## STAFF REPORT

### Pfenning Road Long Plat (LP-25-00004)

Requested Action: Tyler Glahn, authorized agent for Crytyl Enterprises, LLC, submitted an application for a 39-lot plat (subdivision) of 3 parcels totaling approximately 12.49 acres of land. The proposal includes 39 residential lots ranging in size from 4,680 square feet to 31,920 square feet. The subject property is currently zoned Urban Residential with an Urban land use designation.

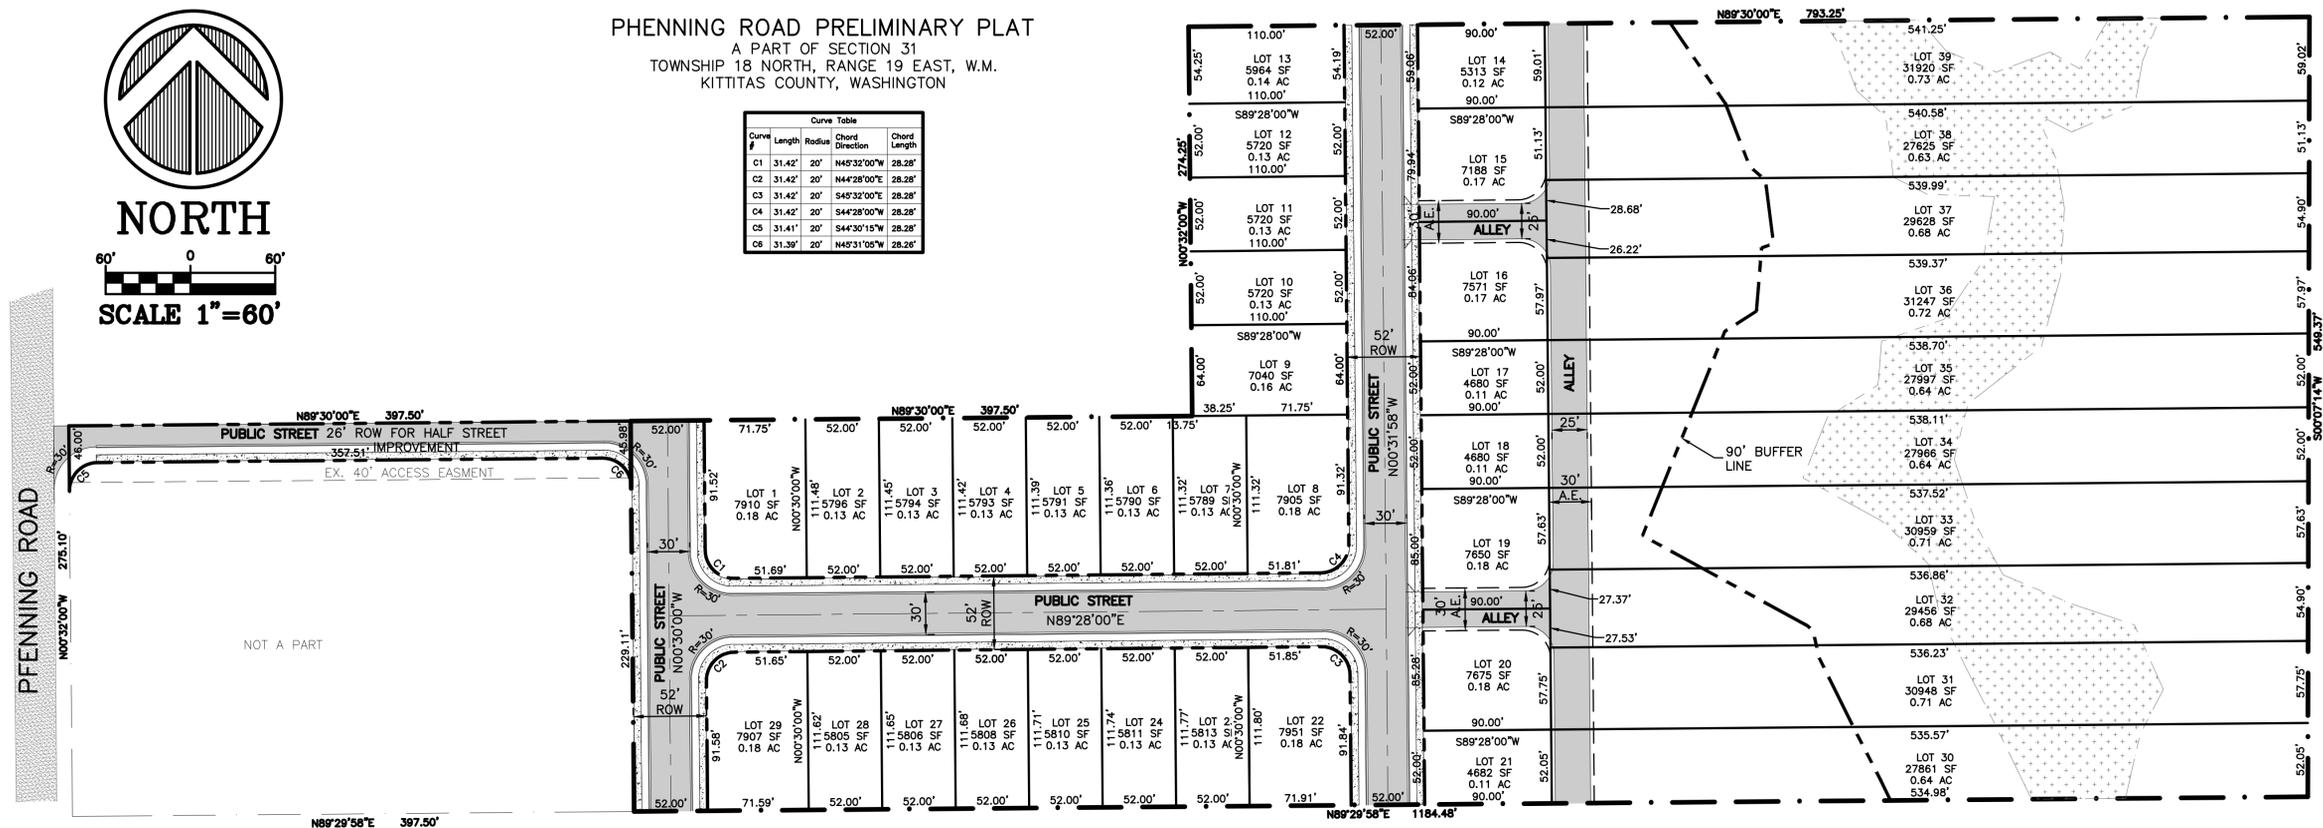
- e. Easement must show a fire apparatus turnaround at termination or within 150 feet on shared residential driveway.
- f. All shared residential driveways shall have a maintenance agreement recorded with the final plat approval that specifies consistent maintenance in accordance with the approved plat/plans.

- h. Current plat design has only one fire access road. Per Appendix D of International Fire Code Section D107.1, (one- or two-family developments): Developments of one- or two-family dwellings where the number of dwellings exceeds 30 shall be provided with two separate and approved fire access roads. It would be acceptable to plat the 39 lots and limit building to 30 dwelling units until such time that it can be shown that future development will connect to secondary fire access road or any acceptable alternate means and method which would reduce the hazard. Any phasing of the project would be required to meet IFC requirements for Fire Department access, turnarounds, and water supply.
